**Response to the EIS for the  
Epping to Thornleigh Third Track Proposal**

**Beecroft-Cheltenham Civic Trust Inc**

**Application SSI 5132**

<b>Date</b>	4 November 2012
-------------	--------------------

Figure 5.6 Cross-section and elevation - New Cheltenham Station concourse building
Note: Indicatively added to future design

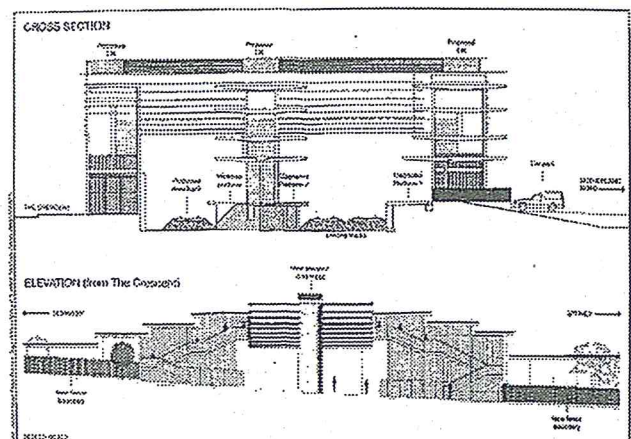
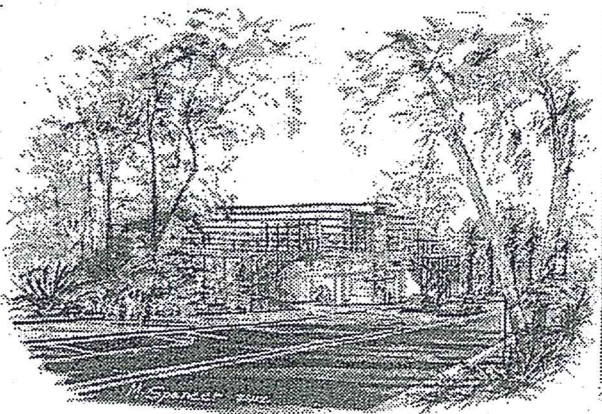
The project proposes the construction of a two storey railway concourse, 13m high, on the site of the existing station. It will have lift and stair access to all platforms, a bus bay and a taxi rank. The scale and location of this indicative structure relative to the natural topography is totally inappropriate for a heritage conservation area. It appears that no effort has been made to design or site a railway station that is sympathetic to the local

environment. The EIS should state that a heritage study and impact statement is necessary in order to determine an appropriate location and design within the BCHCA. Ideally the impact assessment of the proposed railway station should be undertaken as part of the EIS prior to project approval to ensure a viable and sympathetic outcome.

The EIS expresses the view that the concourse structure proposed for Cheltenham is “unlikely to have significant impact on the heritage values” of the houses opposite, mainly because some of them will be screened by vegetation. The Trust disputes this view, and considers that the structure will almost certainly have significant adverse impact on those houses and the area generally. The EIS must require a landscape and arboricultural study and assessment and the submission of a landscape design solution within the railway corridor and its curtilage to minimise the visual impact of the proposed built form which should form part of the overall infrastructure planning.

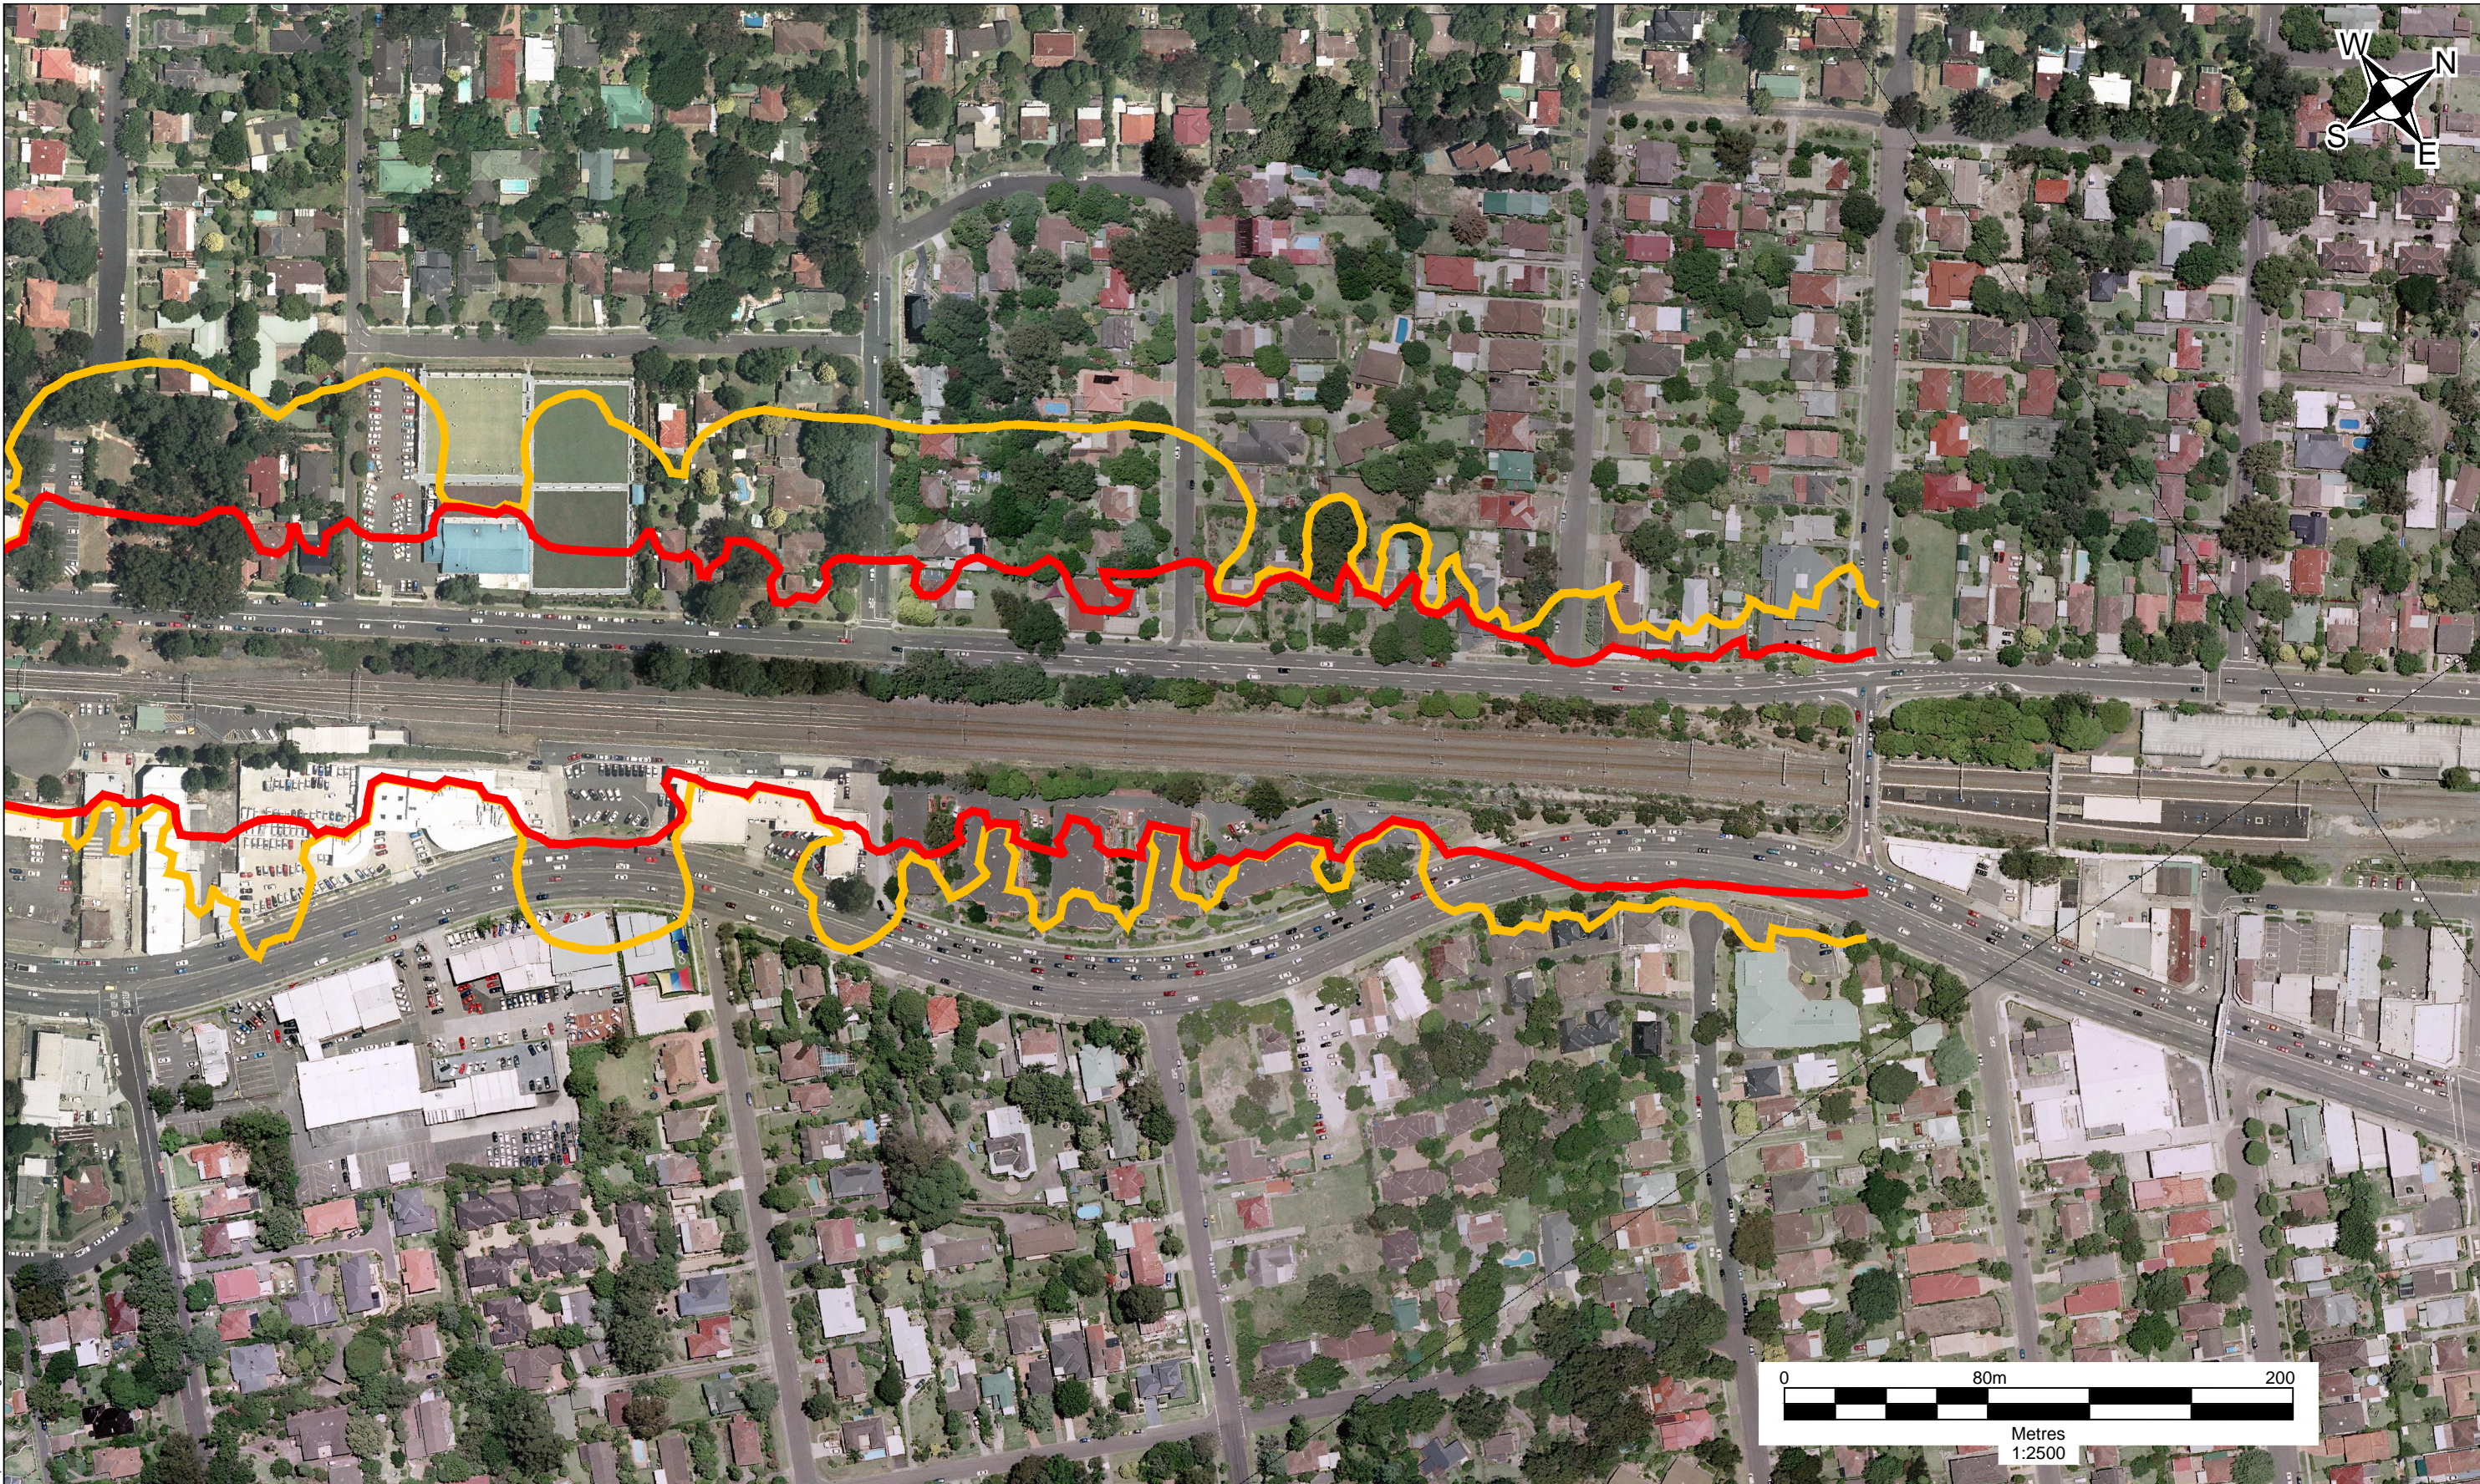
The presentation of the noise contour maps is misleading. It appears that the contours take into account screening from existing structures. While this is acceptable, it leads to a situation where the contours wrap in front of buildings close to the railway. This gives the impression of the lower noise contour passing in front of the building whereas in reality the façade is subject to a higher noise level. There is known to be significant impact from rail freight noise in dwellings at distances greater than 50 metres from the railway line.

Only the contours for the 2026 “with” proposal scenario are presented, which does not allow scrutiny of other scenarios, such as “prior to opening”.

Figure 132: Devlins Creek area of archaeological potential.

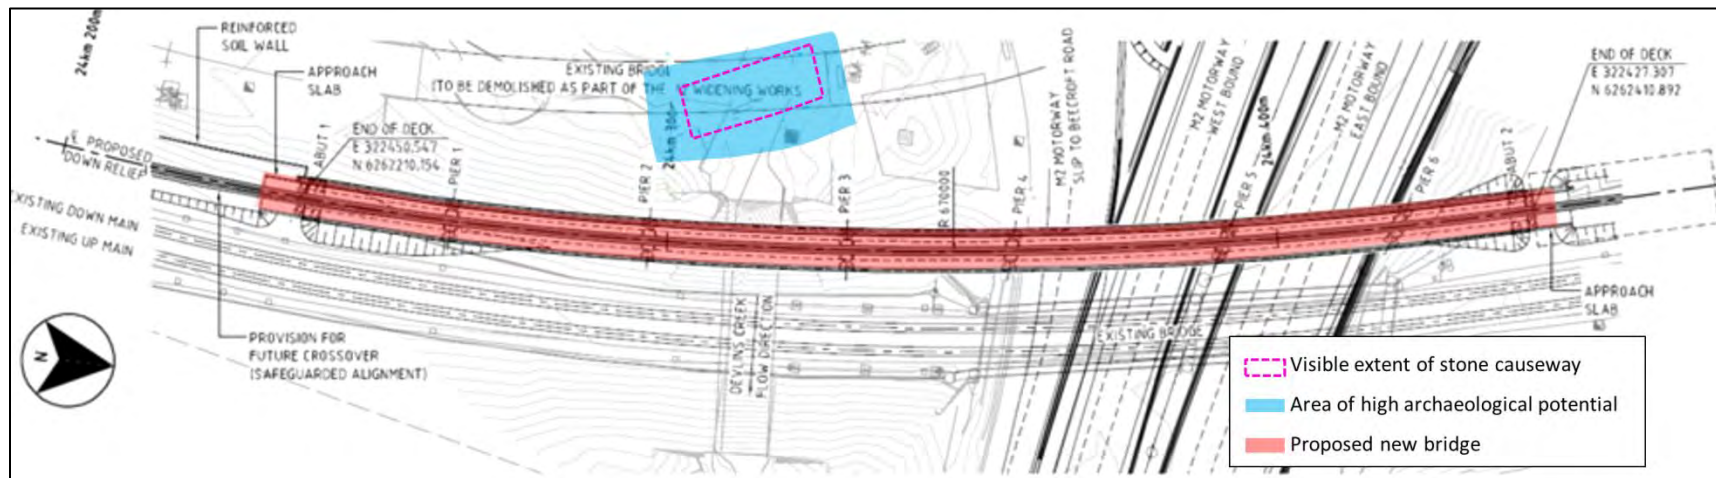
The EIS fails fully to assess the significance and potential impact on the convict built stone causeway at Devlins Creek. Further archaeological assessment by a suitably qualified archaeologist should be required as part of the EIS not post approval. The results of this assessment would then allow an informed approval process with specific and grounded management strategies. It is not possible to ensure the project avoids impacting this significant item unless the causeway is fully identified.

Concept design drawing of proposed changes to Beecroft Station (Parsons Brinckerhoff 9/3/12). Former side platform shaded in pink.

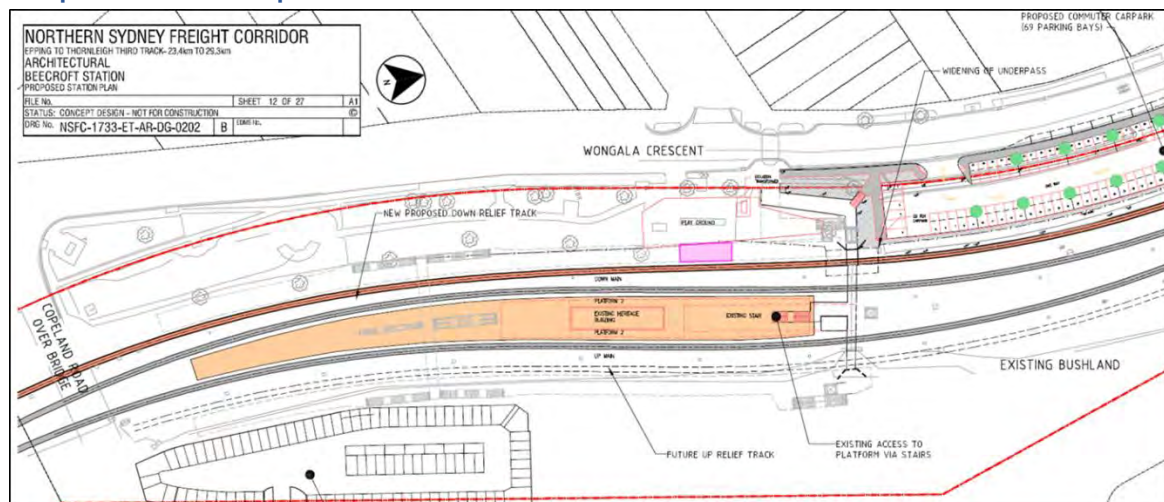
Beecroft Railway Station precinct comprises not only the station but also the neighbouring parkland, children’s playground and the heritage plantings. On the Beecroft Station there are two different sites. The first is the remnant siding which will be removed. It is between the current station and the playground. It is clearly visible from the station and contains a pine tree (visible from the playground) that does not seem to be mentioned in the EIS. This dates from late 19<sup>th</sup> Century. The second is the original station which was south of Copeland Road bridge. This historic original

platform, built in 1895 and in use from the commencement of rail services to the area in 1896, is to be removed. It represents the earliest piece of rail infrastructure in Beecroft. The EIS largely seems to talk of the siding rather than the original station.

Extension of the existing pedestrian subway at the station under the third track should be completed in a manner sympathetic to the heritage status of the existing station.
